CITY OF PORTLAND, MAINE

PLANNING BOARD

October 29th, 2015

Project Name: Subdivision and Change of Use/Renovation of existing building to create Ten Residential Units
Project #: #2015-162; Level III Subdivision and Site Plan
Address: 415 Cumberland Avenue, Portland
CBL: 036 G033 001
Applicant: Patrick Ducas
Planner: Jean Fraser

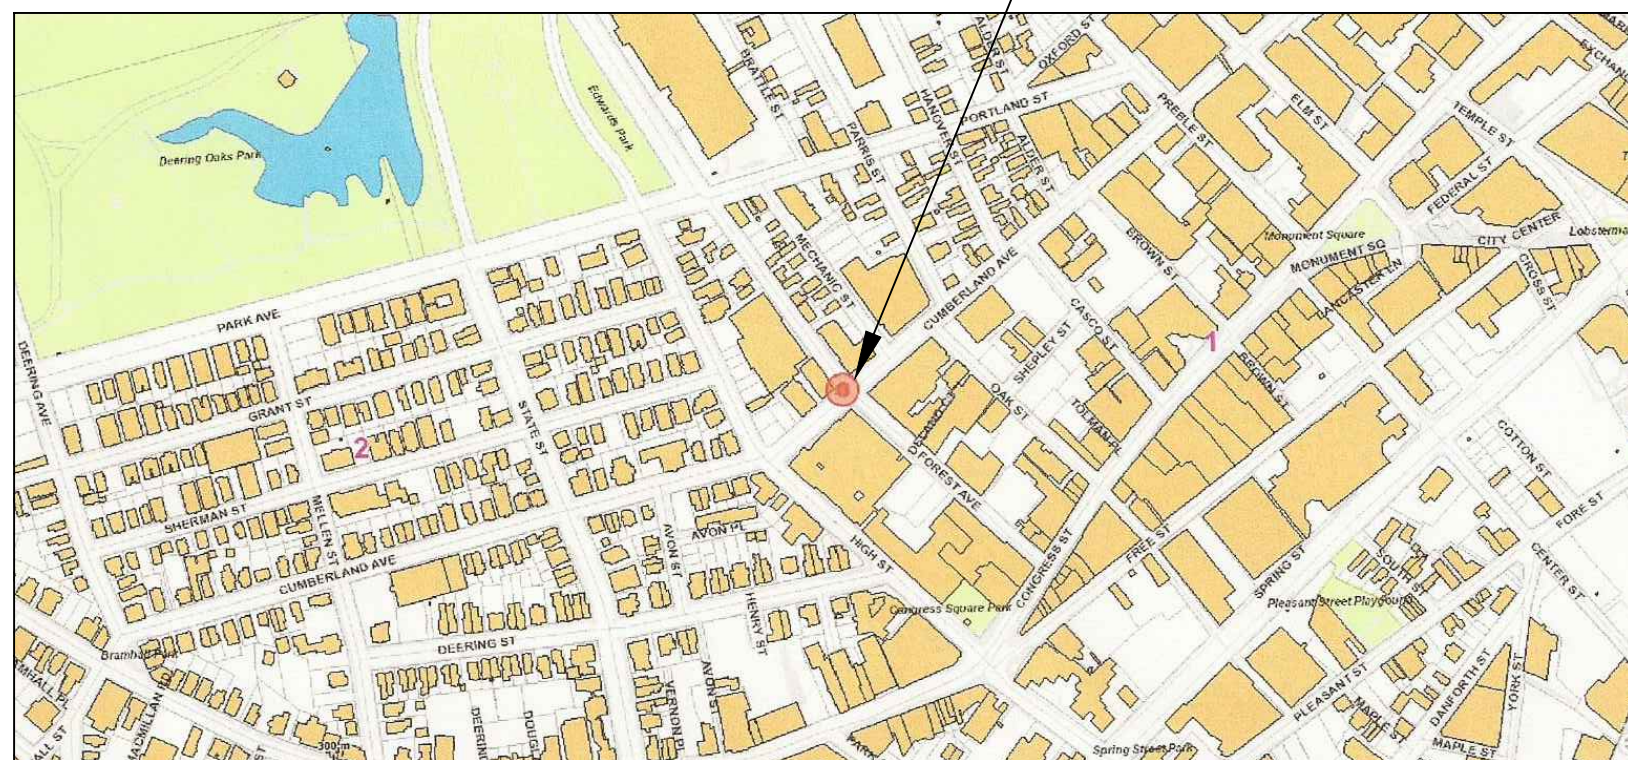
- i. That the Subdivision Plat shall be finalized to the satisfaction of the Planning Authority, Corporation Counsel, and Department of Public Services, and include confirmation regarding the street tree requirements, clarification of easements, and other information along with relevant notes and conditions prior to submission for Planning Board signature; and
- ii. That in the event the property is converted to a condominium, that the recorded condominium documents shall be copied to the Planning Authority.

- i. That the applicant shall submit a revised site plan/plat that shows the location and design of the 4 bicycle parking spaces, the proposed planting in the front garden area including 2 street trees on the site, and the replacement ADA ramp panel in the ROW at the corner of Forest Avenue and Cumberland Avenue (to meet the City's Technical Standards for any work in the ROW), for review and approval by the Planning Authority prior to the issuance of a building permit; and

5 Top Roof drainage plan
1/4" = 1'-0"

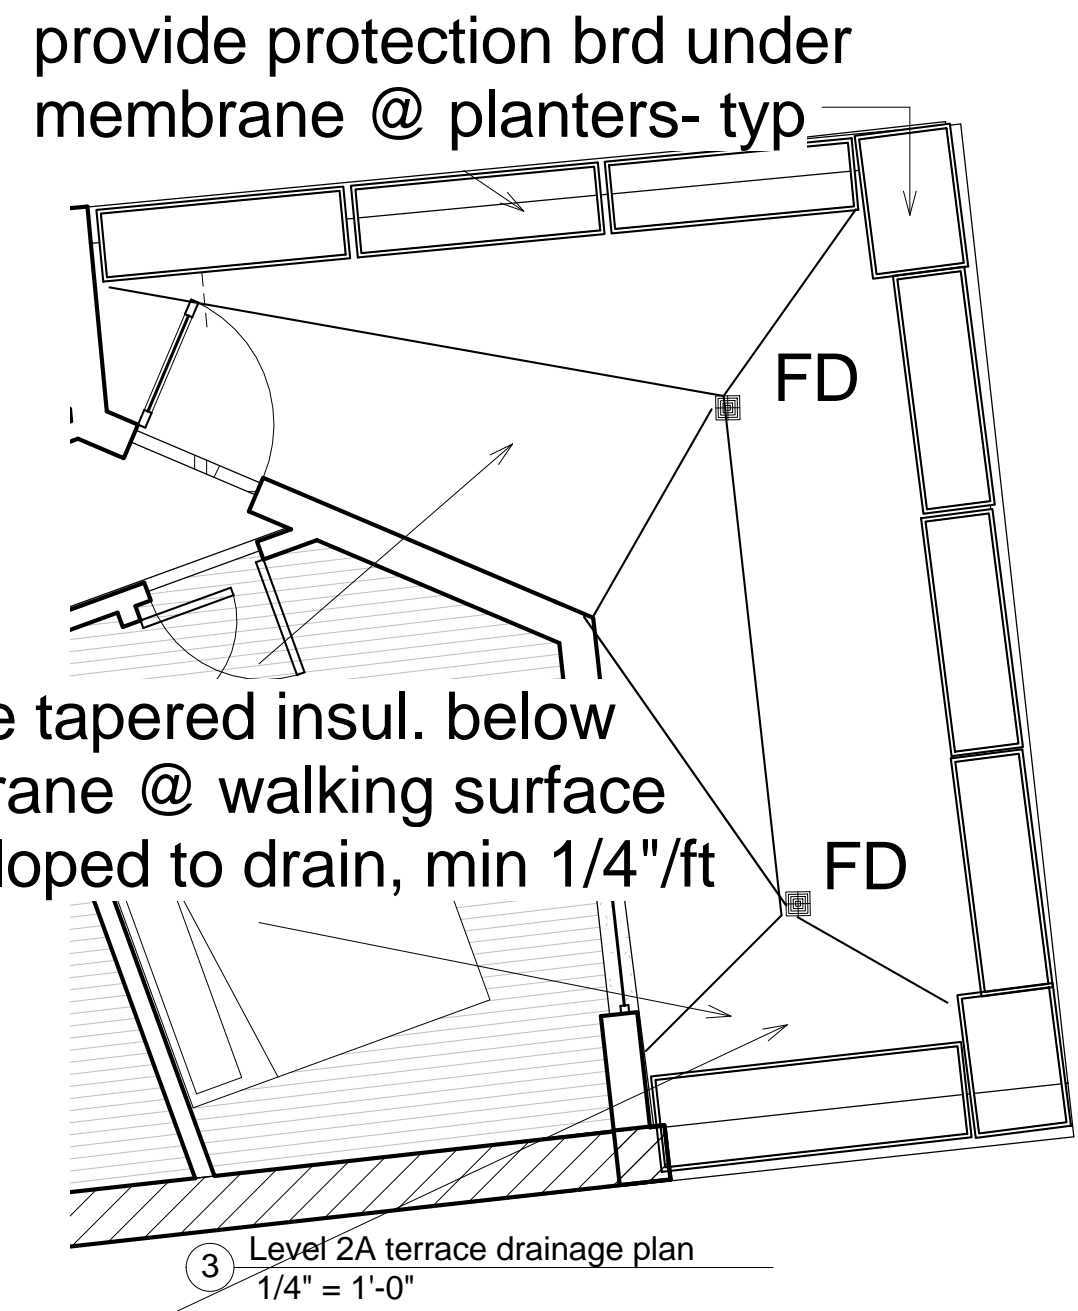
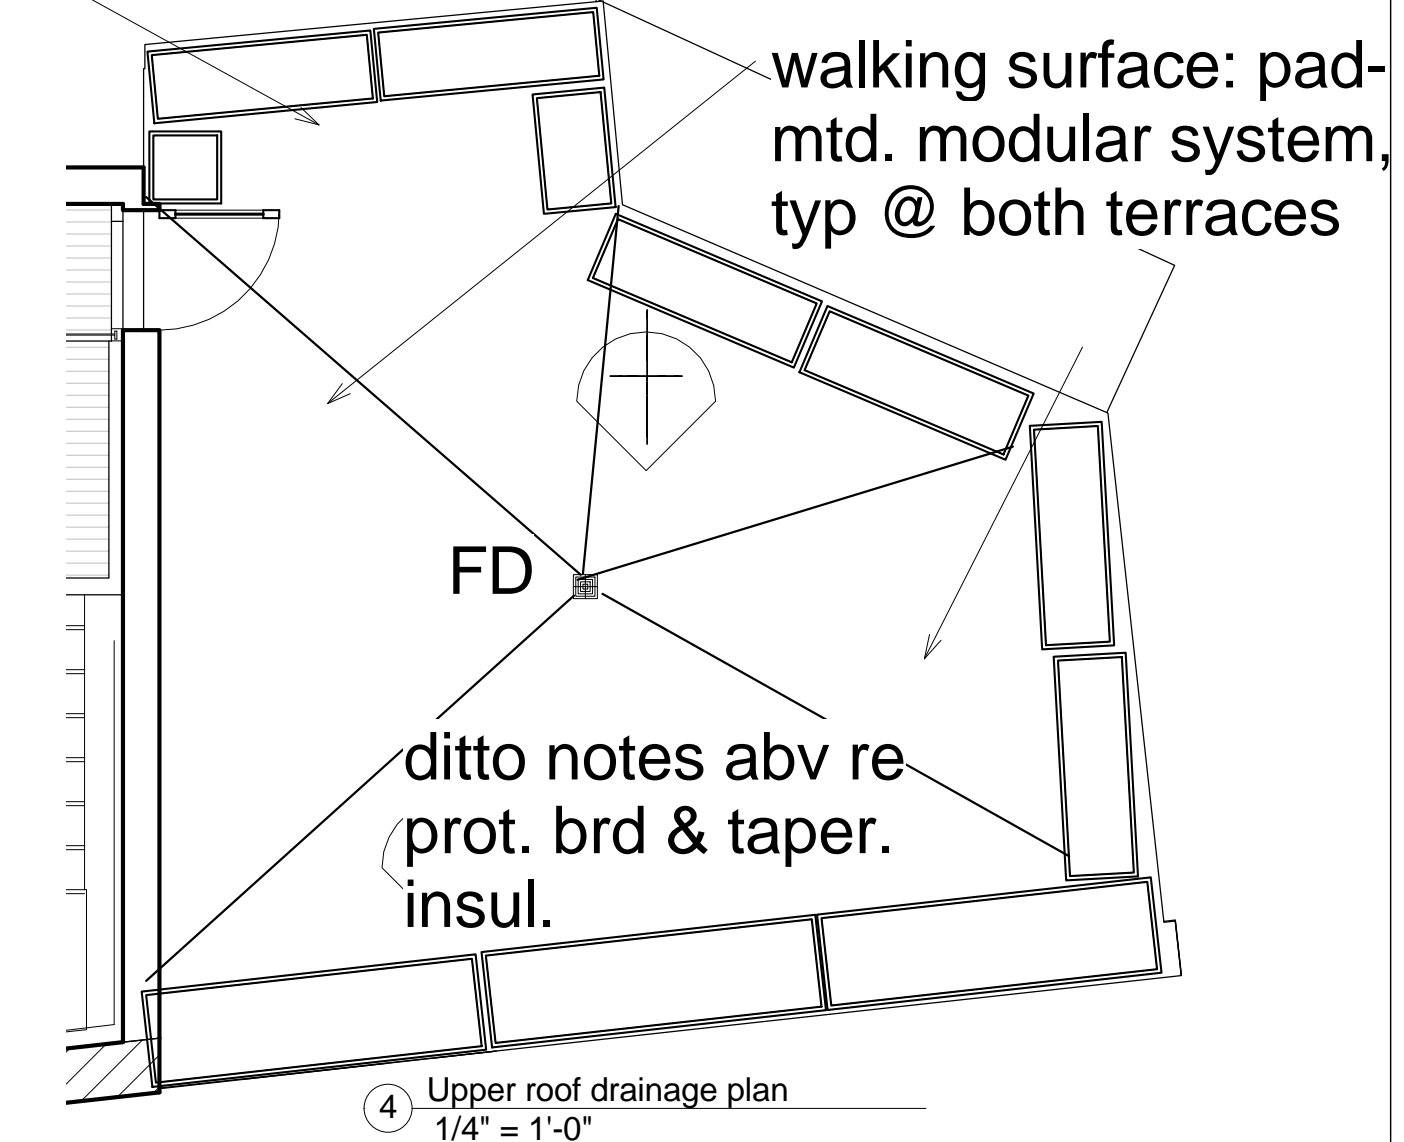
- ii. That the applicant shall submit plans showing the proposals for: A) Any modifications to the roof drainage to meet the Wastewater Capacity Letter conditions (that all roof drainage be directed to the sidewalk or street level); and B) All upgrades to the existing water and sewer utilities at the existing locations, including restoration of the sidewalk (to meet the City's Technical Standards for any work in the ROW); both for review and approval prior to the issuance of a building permit; and
